Marine
Management
Organisation

MMO Reference: DCO/2024/00007
Planning Inspectorate Reference: EN070009
Identification Number: 20049273

12 November 2024

Planning Act 2008, H2 Teesside Limited, Proposed H2 Teesside Order Deadline 4 Submission

FIGURE NUMBER
Figure 1

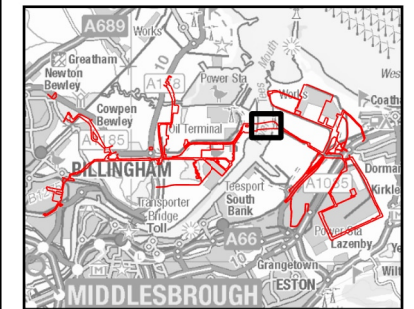
- 1.3.2. The MMO notes that there are no responses to our deadline 2 representation (REP2-066) within this document. In our deadline 2 response point 3.1.2, we noted that the Applicant stated that there is an agreed position between the Applicant and MMO on the location of the crossings entry and exit pits being above MHWS. Although the maps originally provided showed that the pits are above MHWS, the MMO queried the data set used to inform the MHWS line. The MMO sought the distances from the pits to MHWS, to ensure that they are a sufficient distance away from marine receptors. The MMO requested that this topic is changed from 'agreed' to 'ongoing discussion' until this clarification is provided. The MMO has now received this information on 21 October 2024, and we are content with both the Ordnance Survey (OS) Mastermap dataset used and the distances to MHWS. Please see Annex 1 for the further information received.

Name	Distance to MHWS (m)
Microtunnel launch	56
Microtunnel Reception	90

Figure 1: Distances from River Tees HDD pits to MHWS. Information and images provided by H2 Teesside Limited.

FIGURE NUMBER
Figure 2

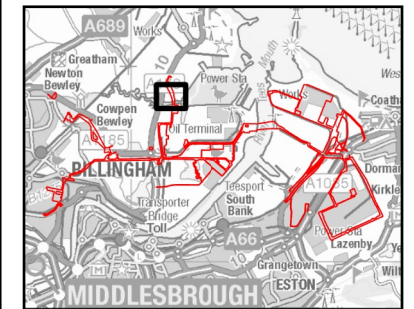
Name	Distance to MHWS (m)
HDD Entry	518
HDD Exit	94

Figure 2: Distances from Greatham Creek HDD pits to MHWS. Information and images provided by H2 Teesside Limited.
